PRE-HEARING STAFF ANALYSIS

Rezoning Petition No. 2008-048

Petitioner: DTJT Properties, LLC

Request: I-1 (CD), light industrial conditional to I-2 (CD), general industrial conditional

REZONING PLAN

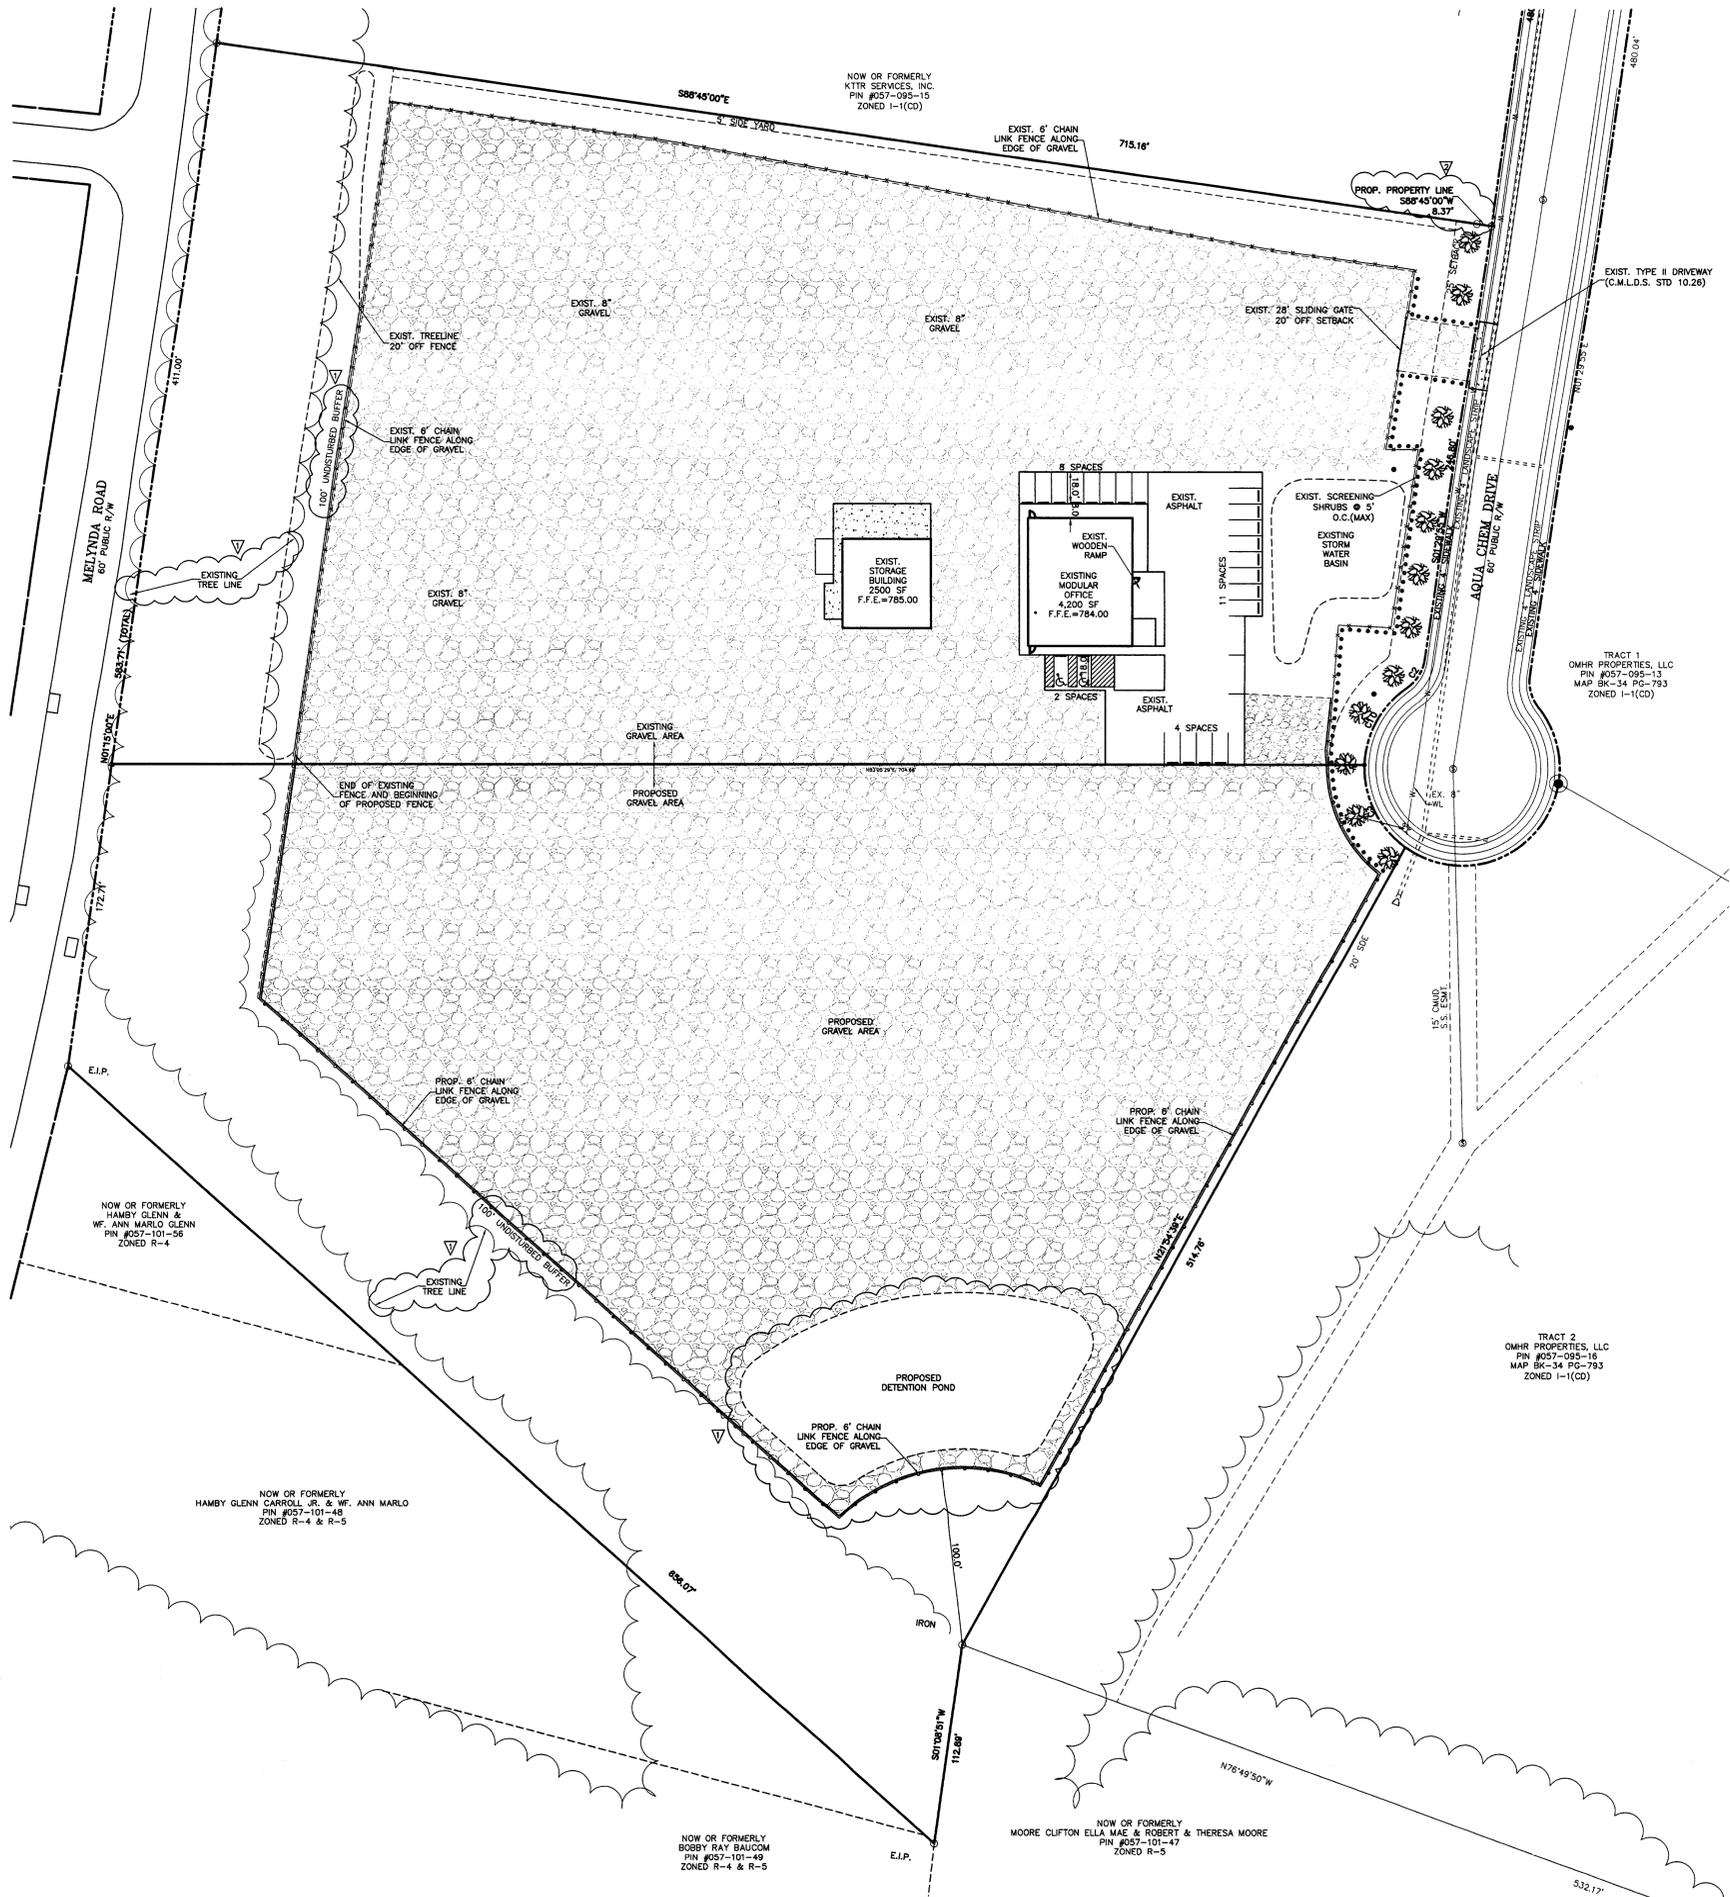
- The proposed driveway to Aqua Chem Drive needs to be paved for a distance of 100 feet from the back-of-curb.
- To eliminate the conflict of bumper overhang with pedestrians on sidewalks along parking areas, a 7-foot wide concrete sidewalk or a combination of a 5-foot sidewalk/2-foot planting strip needs to be provided from the front of the parking spaces. The CLDSM detail number 50.09B needs to be referenced for the 90 degree parking space design.

- Along Melynda Road, the petitioner needs to provide new curb and gutter, an 8' planting strip and 5' sidewalk.
- As shown on the site plan, there is an existing gate at the driveway entrance to Aqua Chem Drive. The gates must open and be recessed into the site a sufficient distance to store an entering vehicle without encroachment into the right-of-way or setback. This distance measured between the gates and the right-of-way is dependent on the length of the largest truck accessing the site and will be reviewed during the building/driveway permit process.
